PLANNING APPLICATION CONSULTATION RESPONSE

Application Number:	3/2024/0395
Proposal:	Approval of details reserved by conditions 5 (cycle storage), 12 (SW drainage), 13 (water mains), 14 (hard and soft landscaping), 17 (construction SW management plan) and 18 (operation and maintenance manual) from planning permission 3/2021/1134.
Location:	Land east of Chipping Lane Longridge

Lead Local Flood Authority Position

Title: Developable Areas Plan

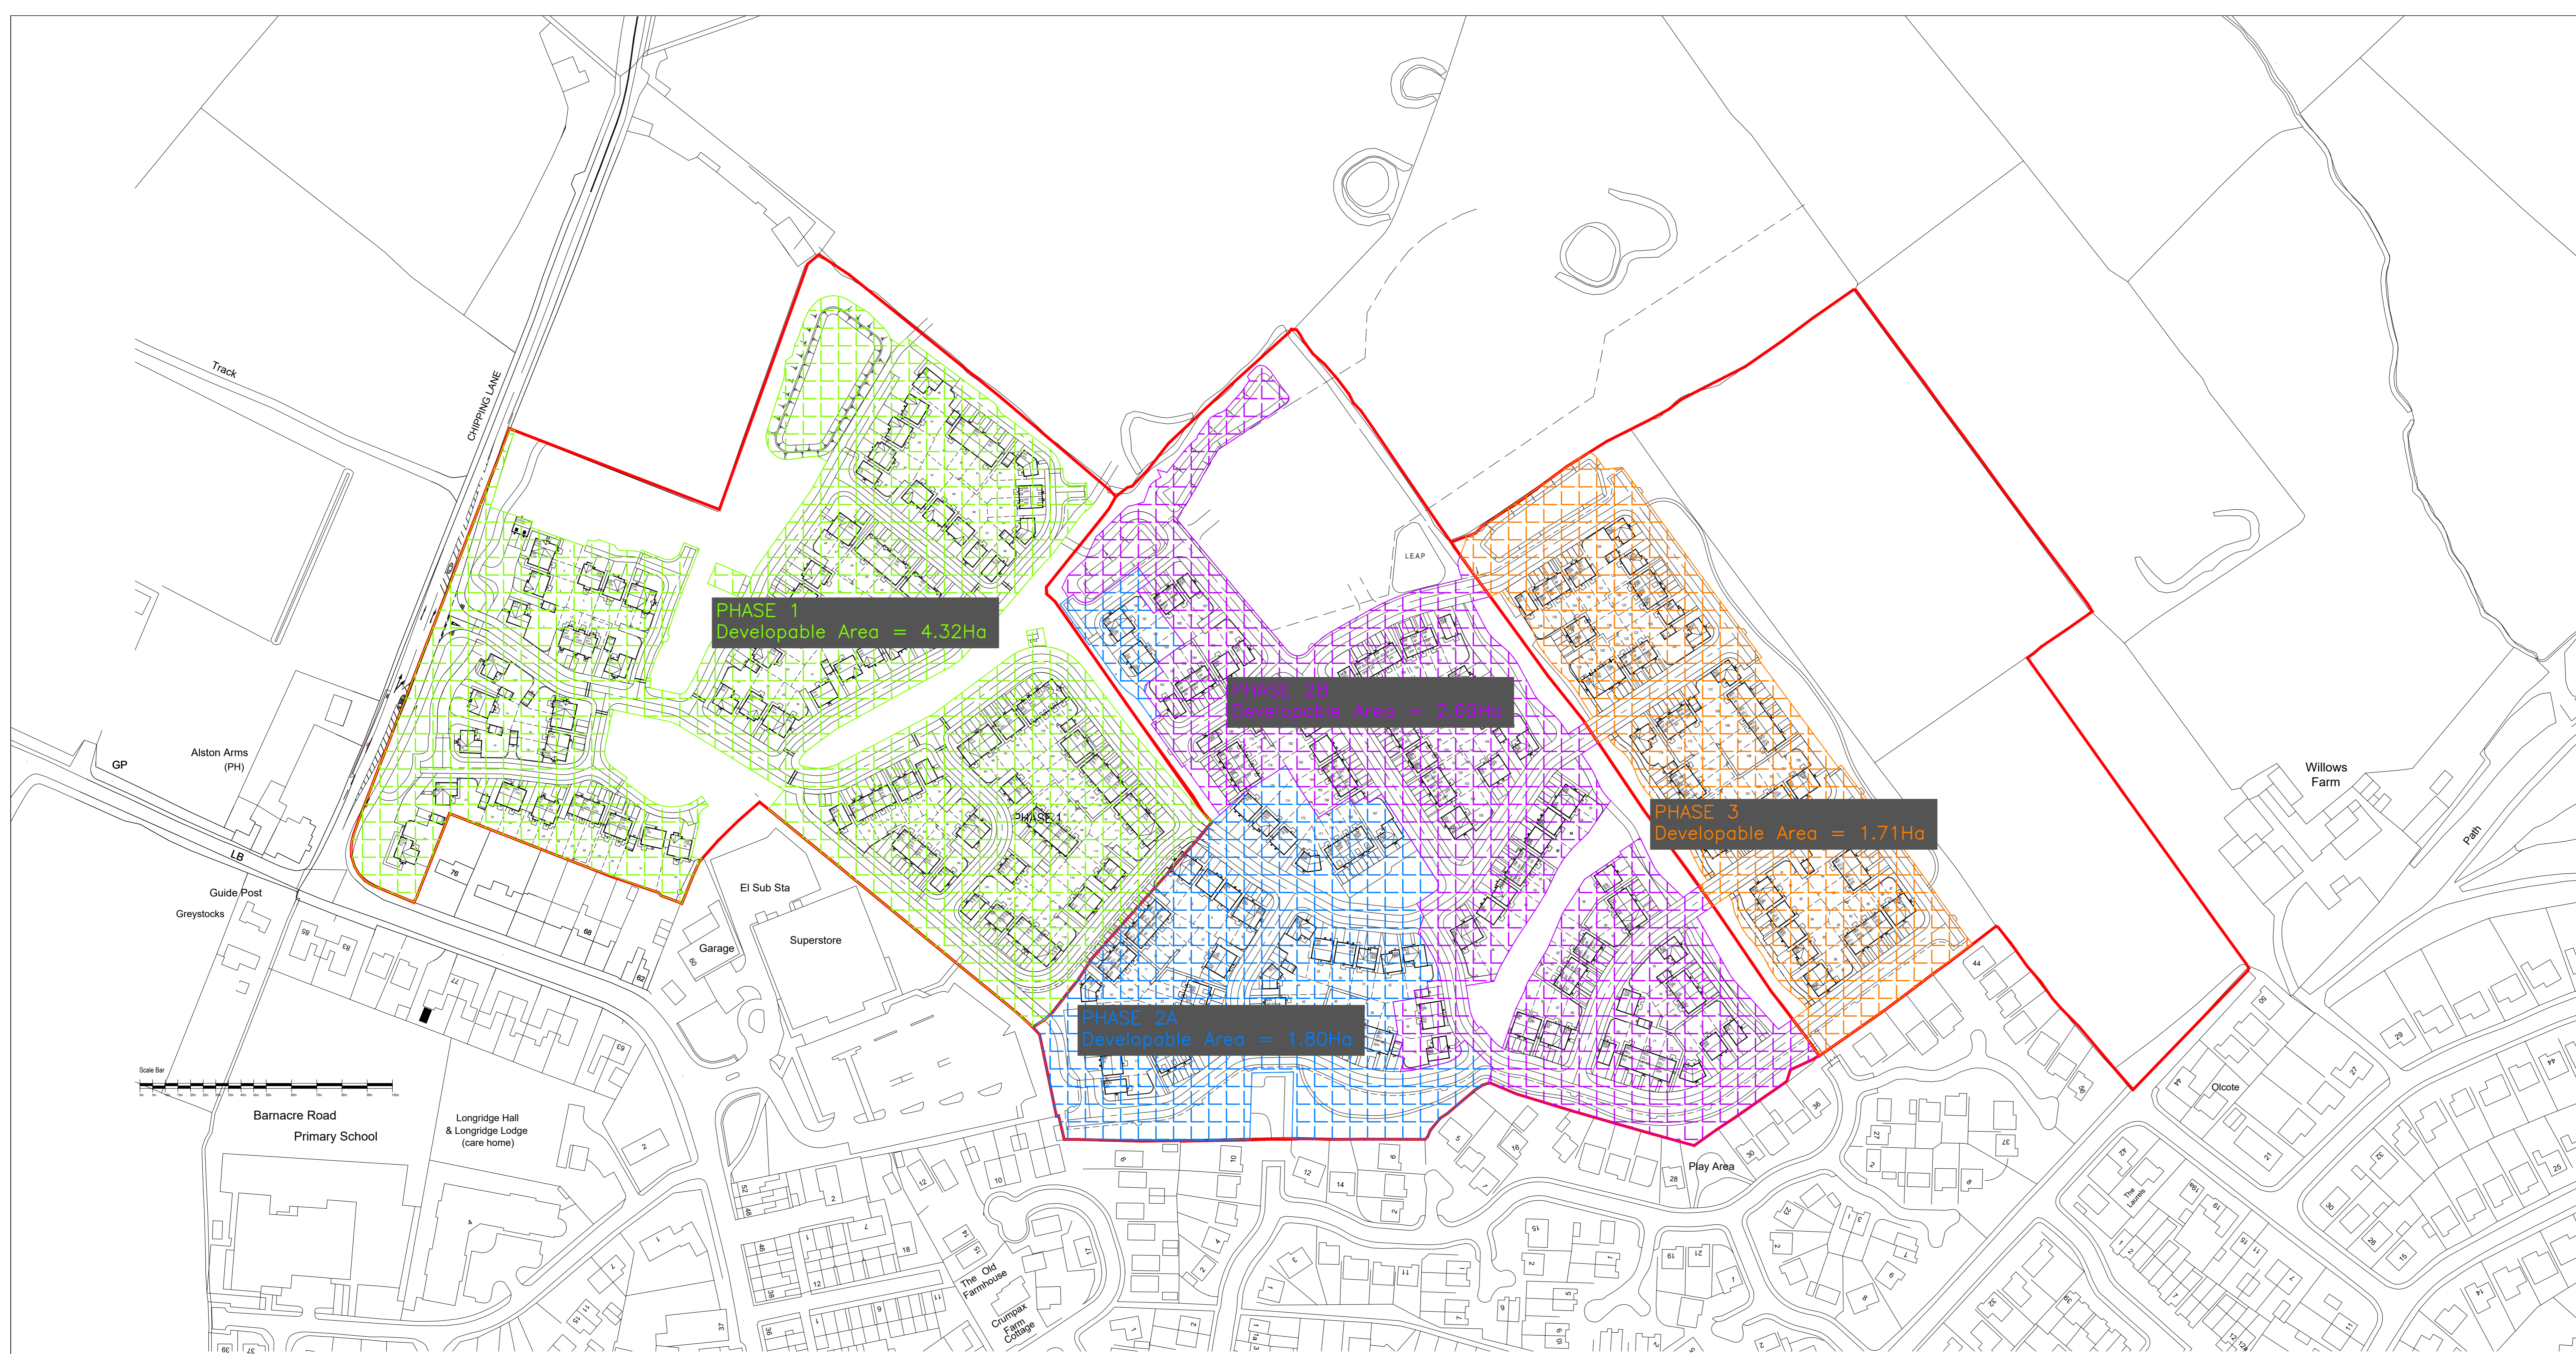
- The applicant has failed to provide evidence of a drainage layout depicting the proposed controlled discharge rates for this development.
- The applicant has failed to demonstrate through the provided drainage calculations that the discharge rates will be restricted to the previously outlined rates. In addition to this, as there is no evidence of the hydrobrake details within the calculations

showing the restricted discharge rate, the calculations also show the system exceeding the proposed discharge rate in the 100 year storm calculations.

Description
Surface Water Management Plan - Phase 2 & 3

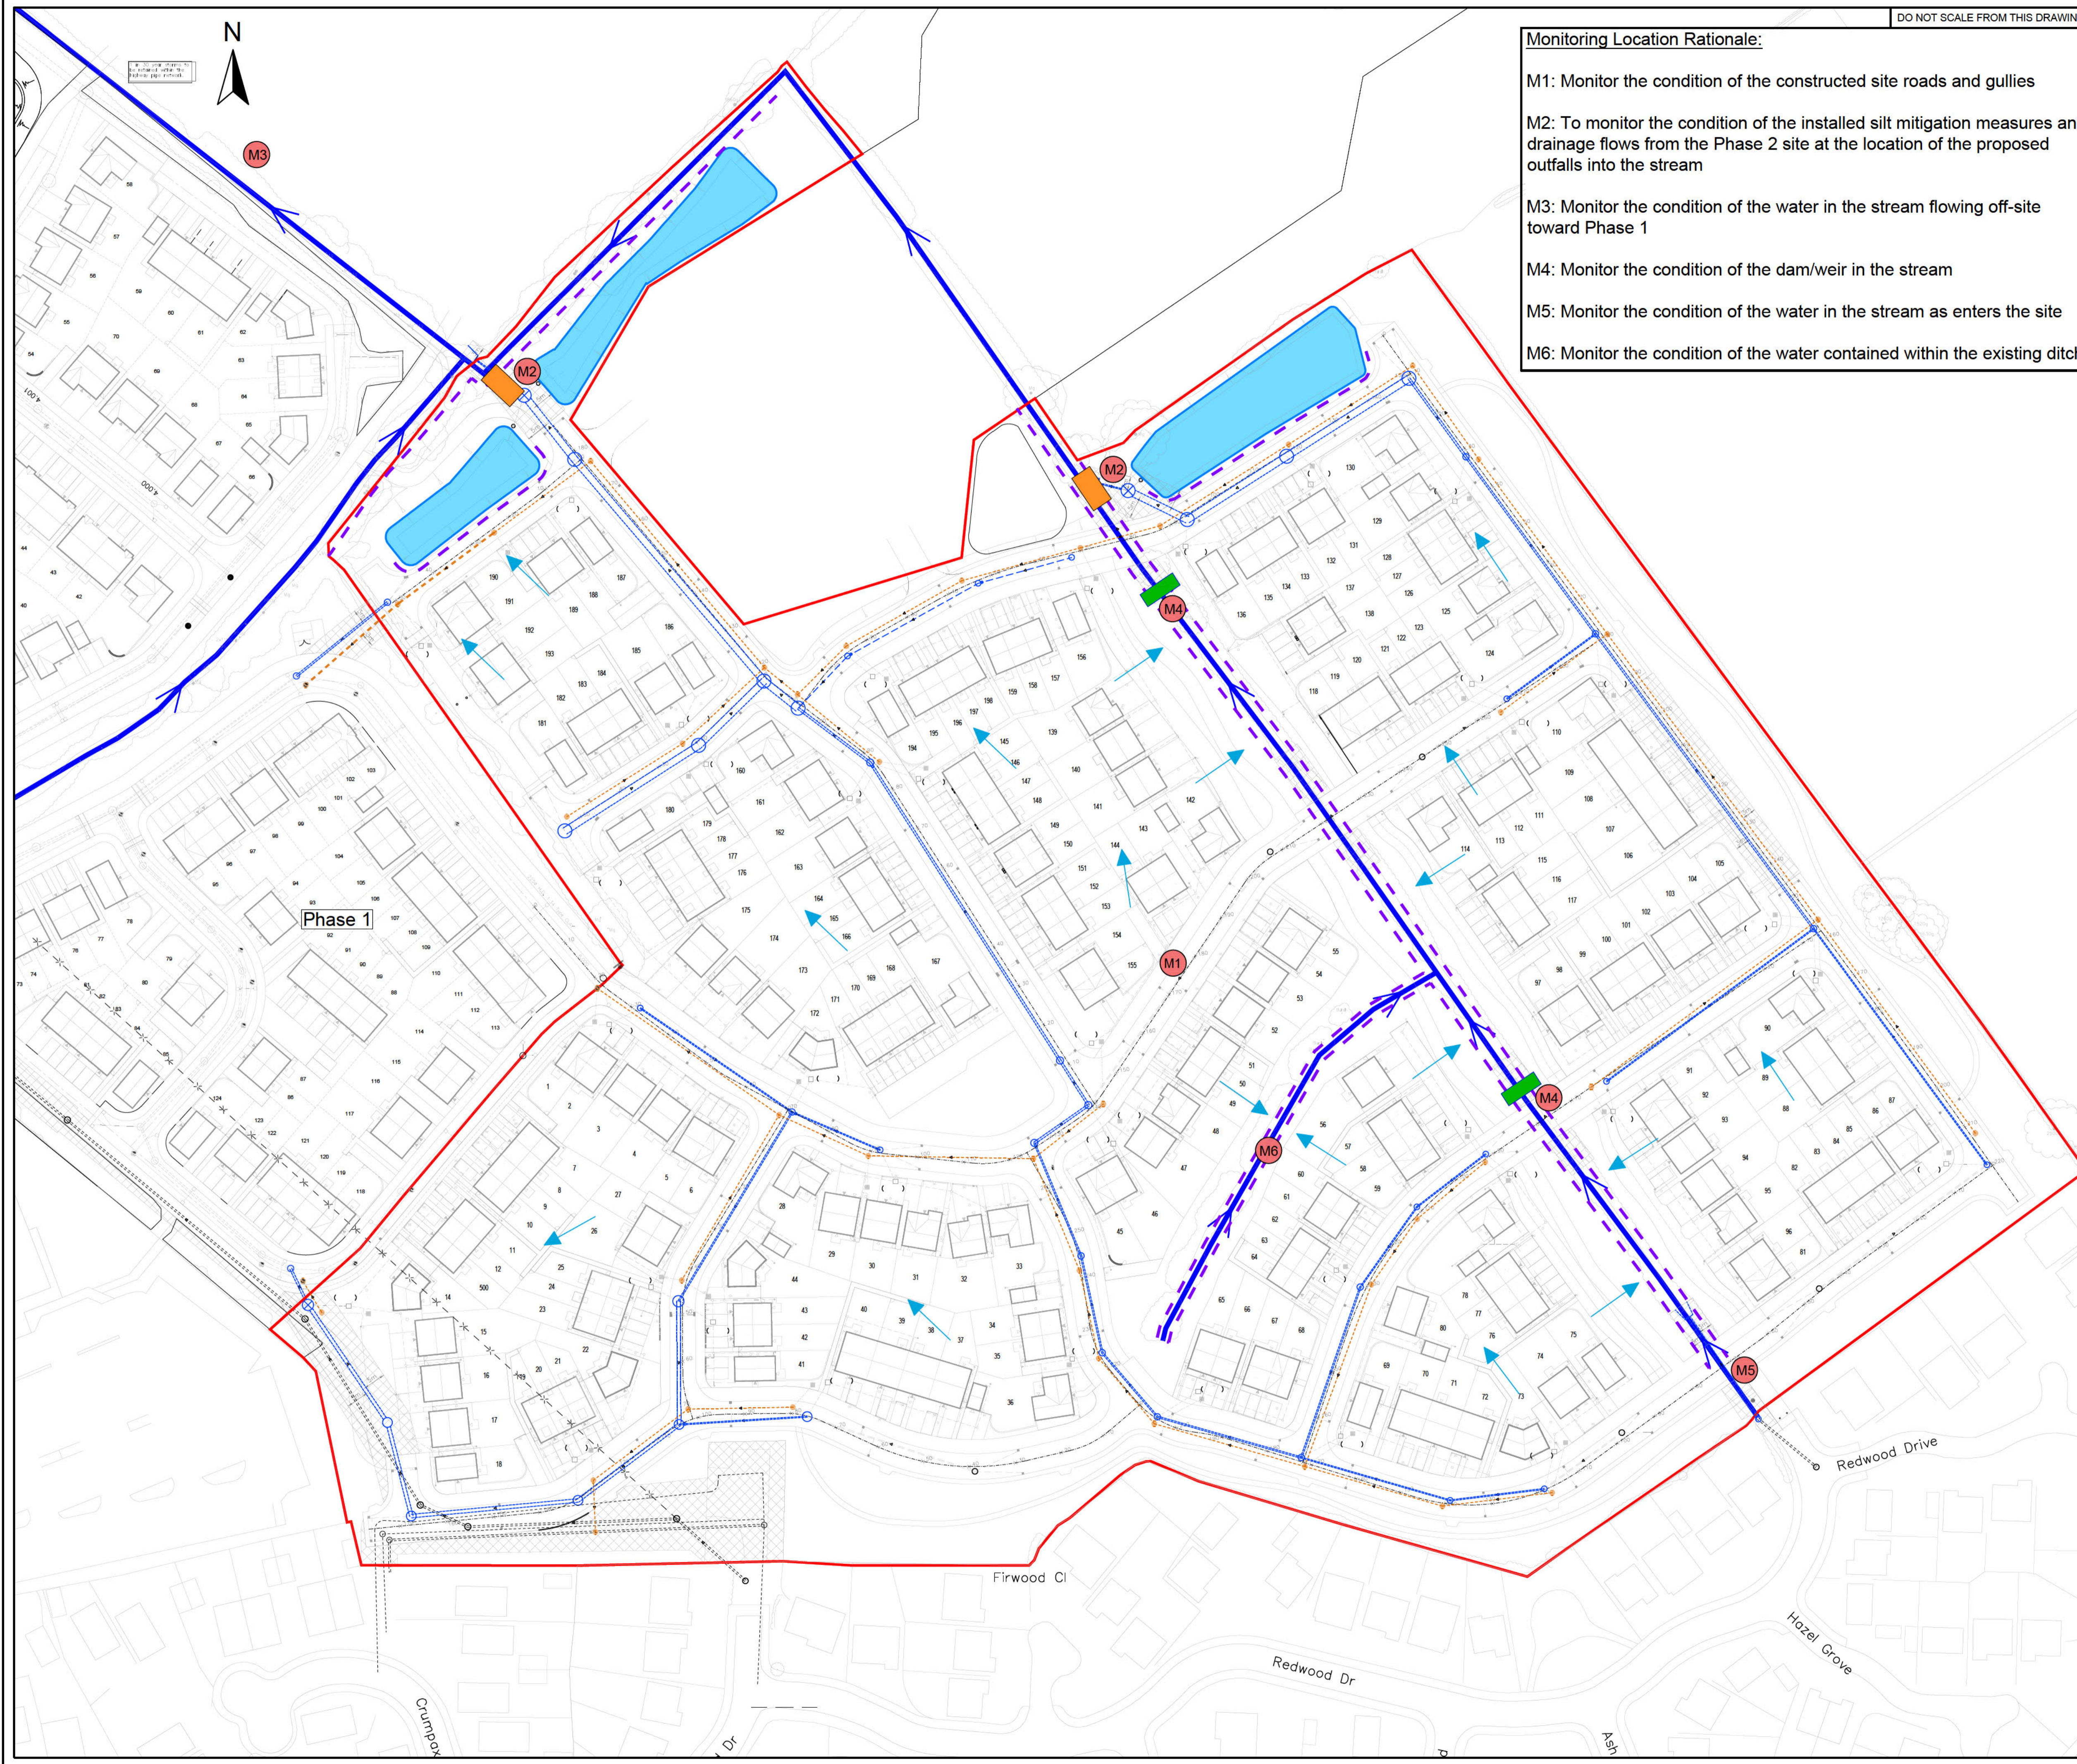
The applicant has stated that during construction, flows will for phase 2 will be directed towards attenuation basin 2b, however the Local Planning Authority should take note that checks of the area, indicate that this area is currently being used as an area of hardstanding or an area for materials for construction, as well as the development area in question being currently under construction at present.
